Ferry Wharf Residential Development – State Significant Development Section 96 (3) Application

I refer to the documentation provided by Payce Communities Wentworth Point Pty Ltd (Developer) for the proposed modification to the State Significant Development SSD 6387 consent (Consent) for Ferry Wharf residential development, Burroway Rd, Sydney Olympic Park.

It is noted that the application seeks to modify the Through Site Link.

Project Title
JEWEL RETAIL
1 BURROWAY RD, WENTWORTH POINT, THE WHARF SITE.
SYDNEY OLIMPIC PARK
Drawing Title
CAFE DESIGN

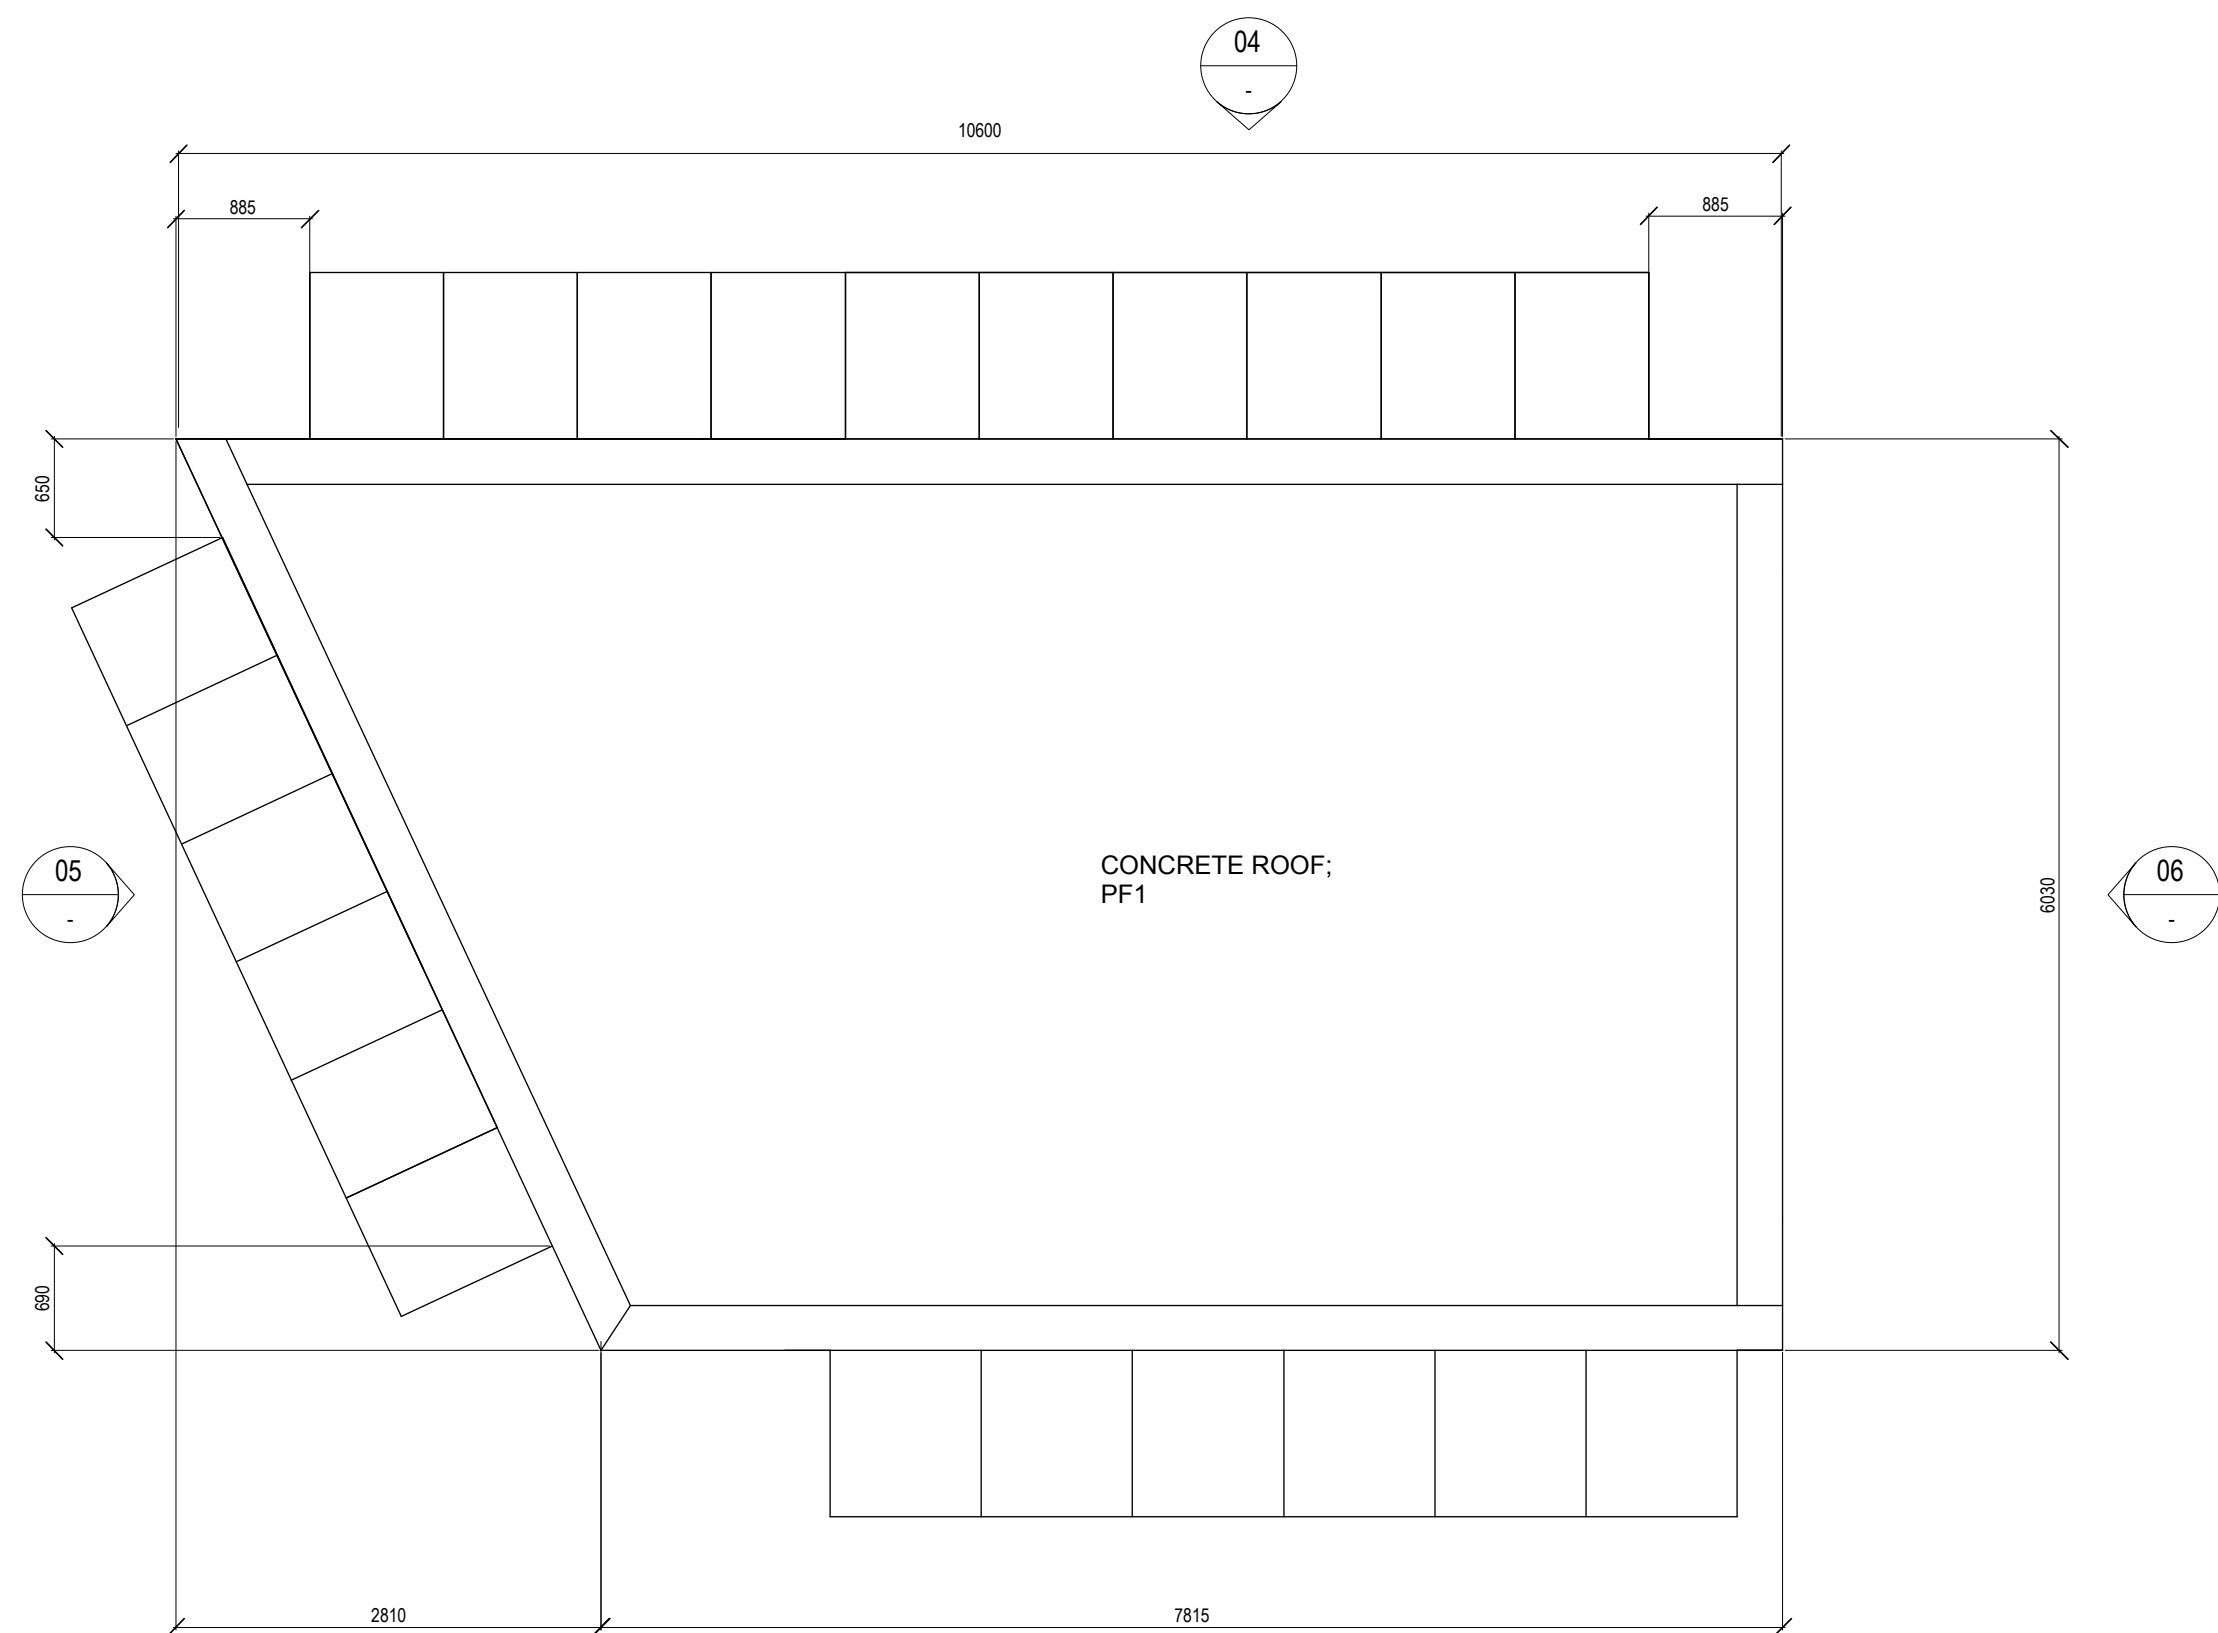
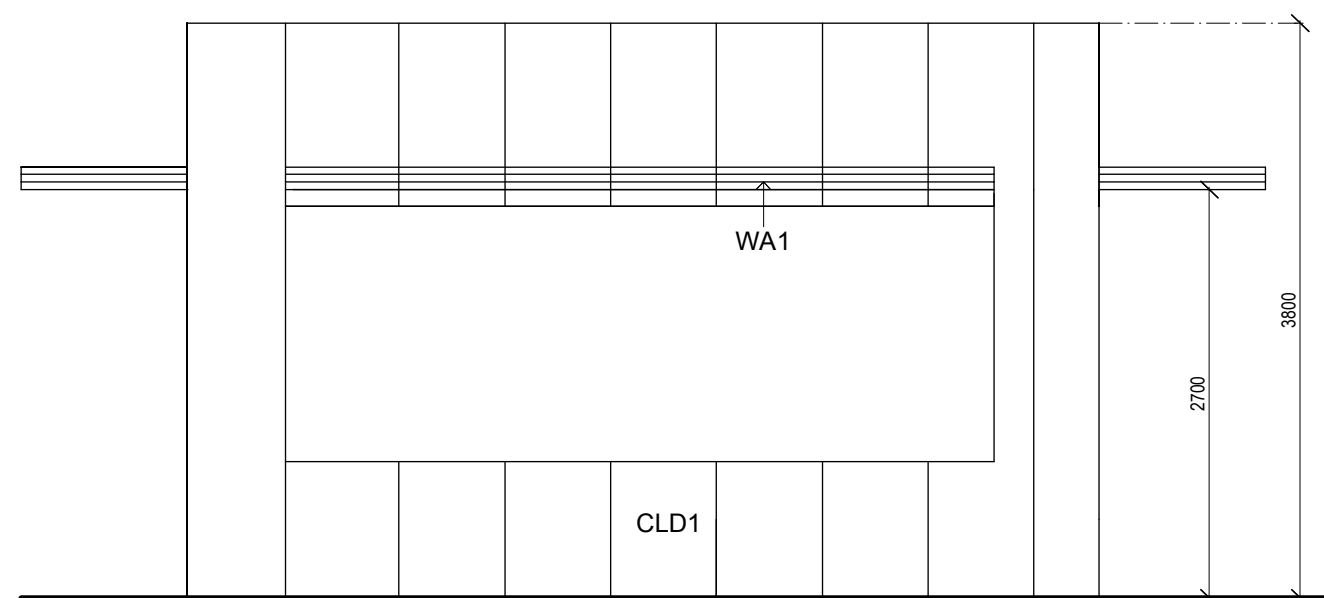
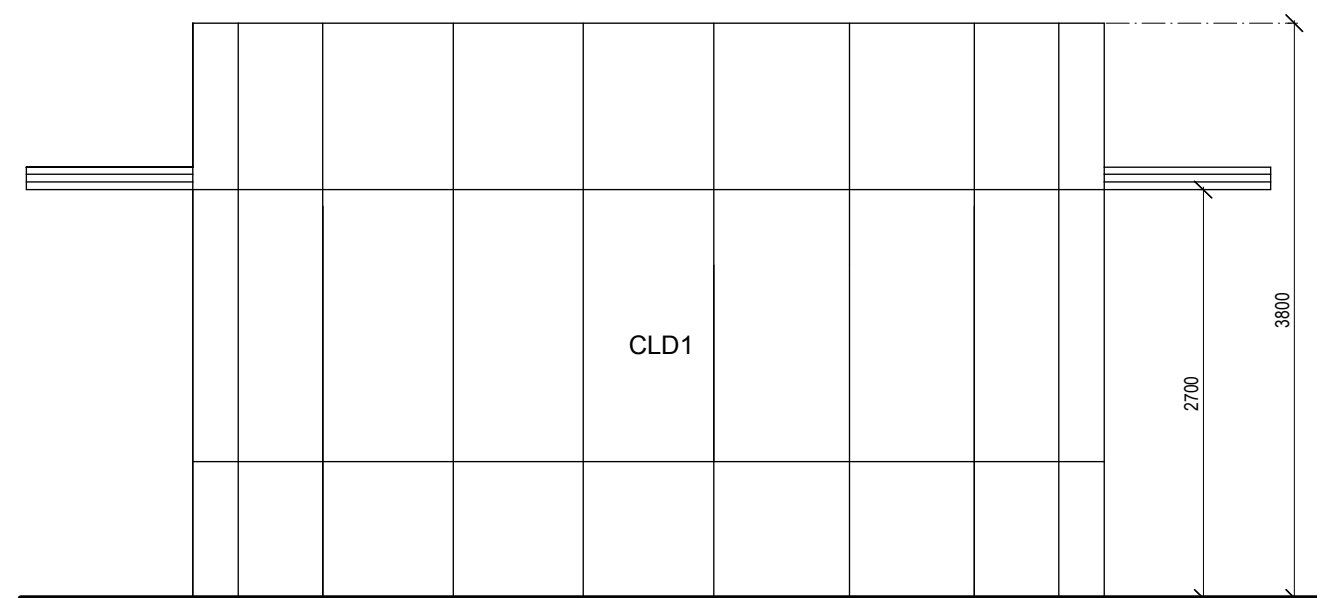
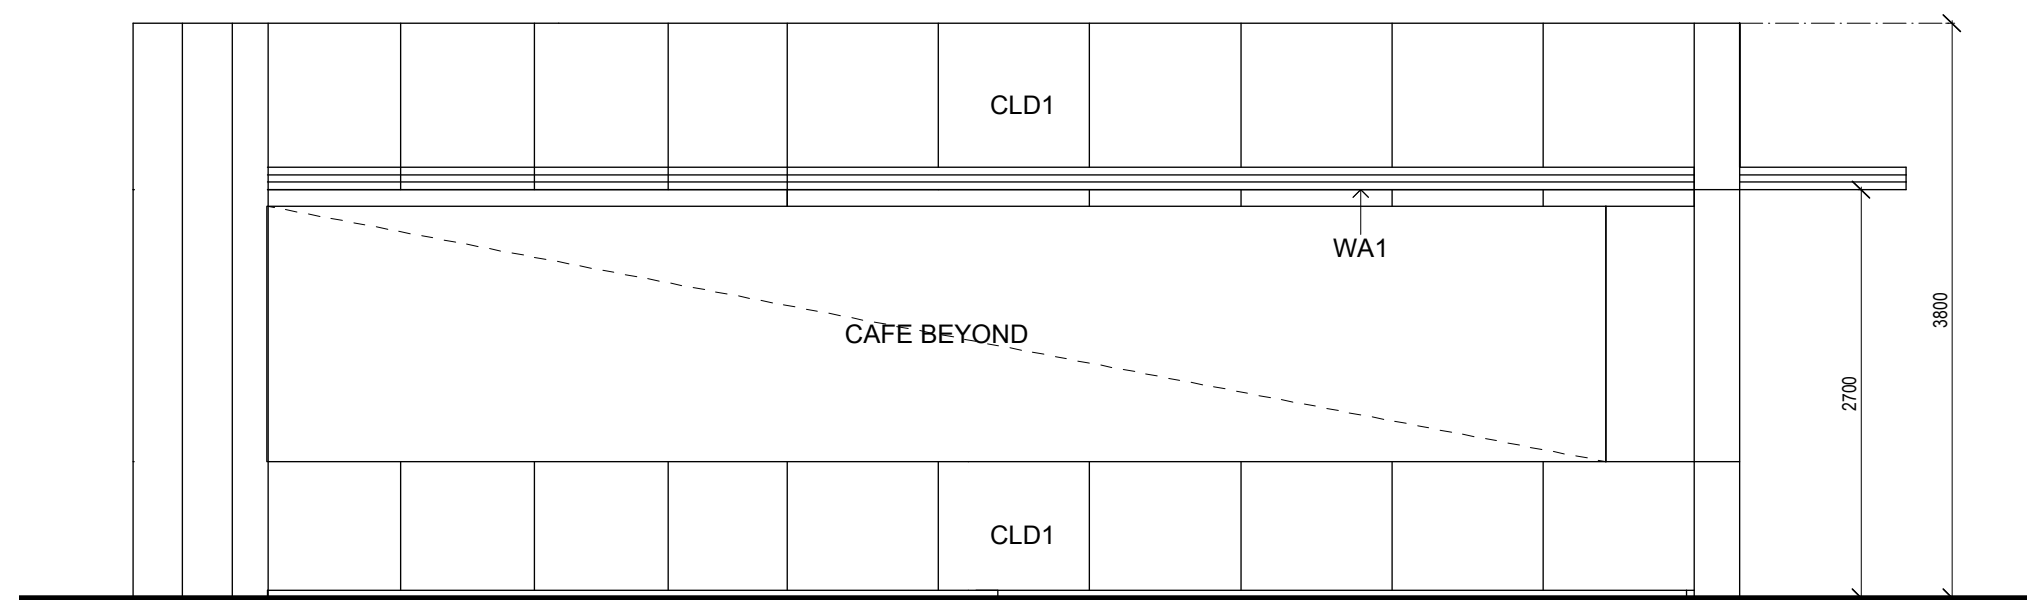
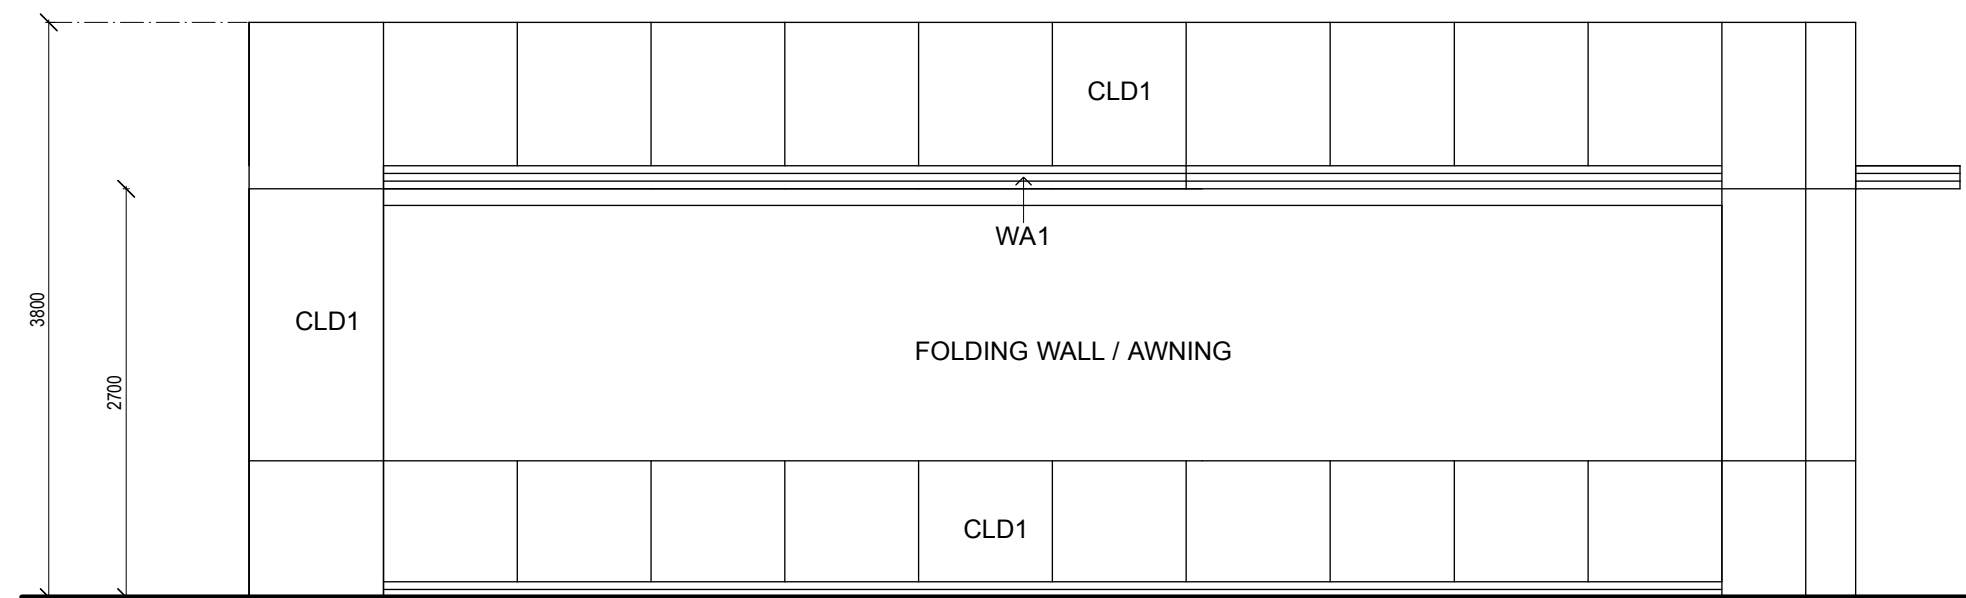
- The proposed location of the cafe does not fit with the intent of the Through Site Link. Consideration should be given to setting back the cafe to align with the western retail frontage to help maintain a clear 13m width for the full length of space.
- The current proportions of the cafe are excessive. The Gross Floor Area of the cafe should not exceed 20 sqm.

Project Title  
**JEWEL RETAIL**  
1 BURROWAY RD. WENTWORTH POINT, THE WHARF SITE.  
SYDNEY OLYMPIC PARK  
Drawing Title  
**ROOF PLAN & SECTION**

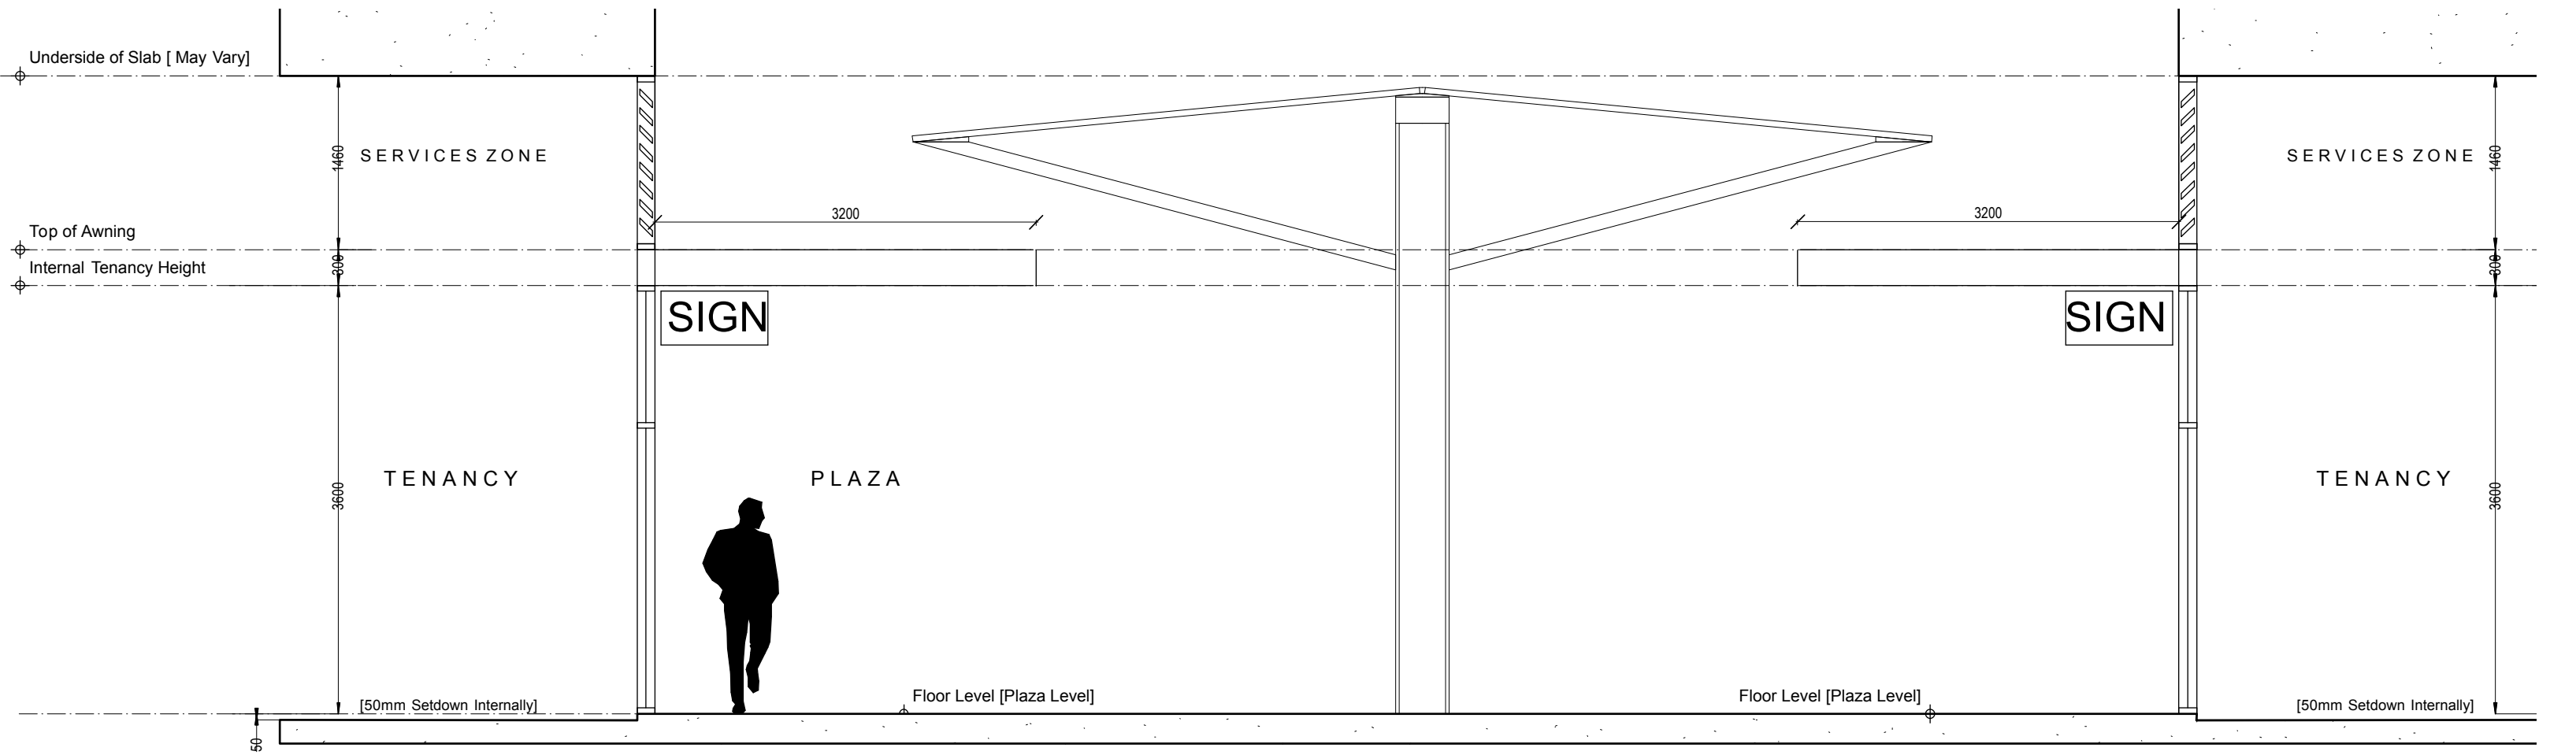
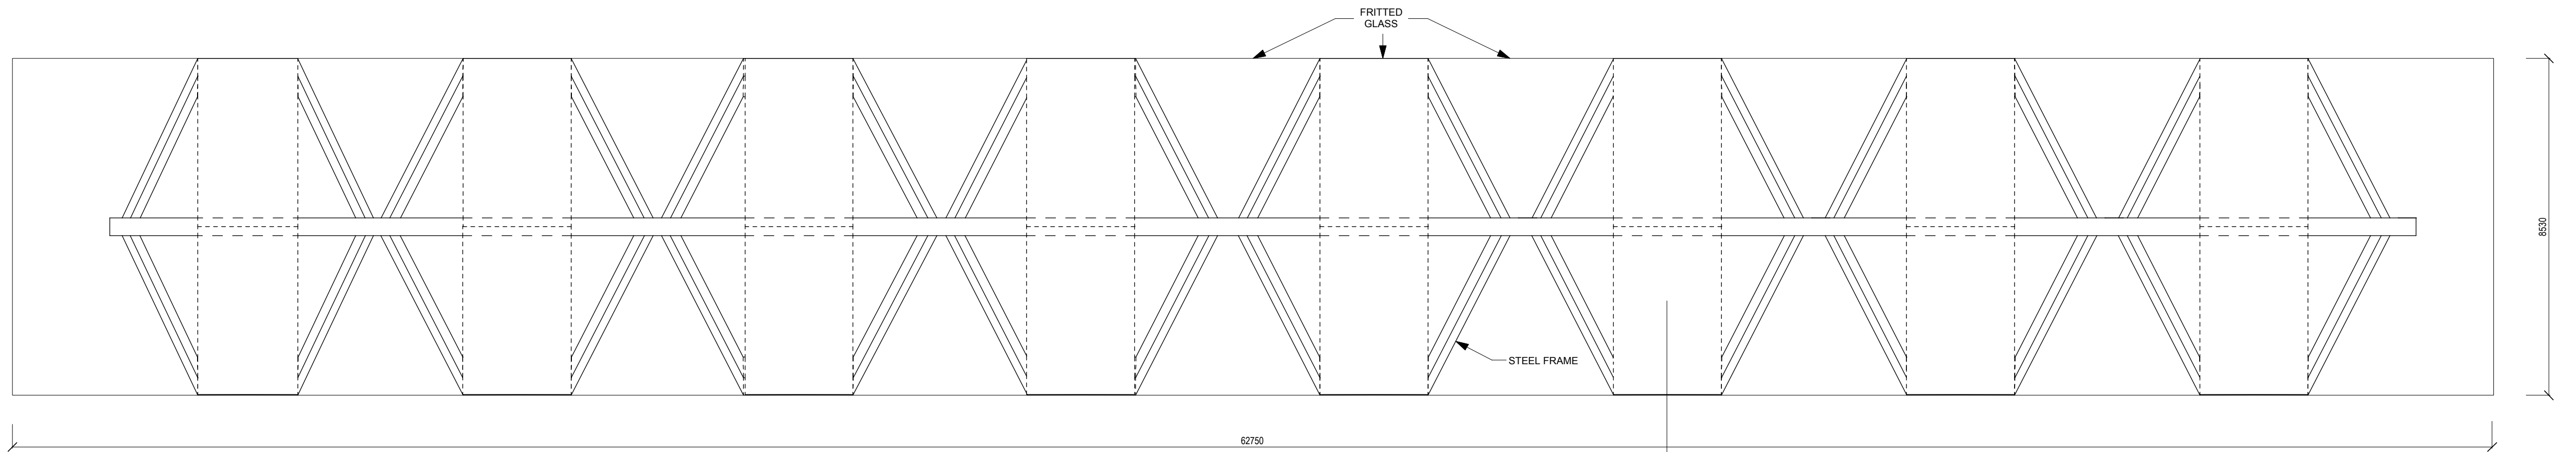
- The proposed steel support structure has a heavy appearance. The structure should be a light weight, finely detailed support system.
- The centralised columns obstruct the space. Consideration should be given to repositioning the columns along both edges of the space, which should also enable the structure to be minimised.
- Height of the canopy is too low and appears to enclose the space. The height of the glass canopy should be at least 7m to provide for a grander scale and improved amenity.
- Limited natural light. Consideration should be given to providing additional glazing to the retail awnings in addition to the proposed glass canopy and the canopy should be fully glazed.
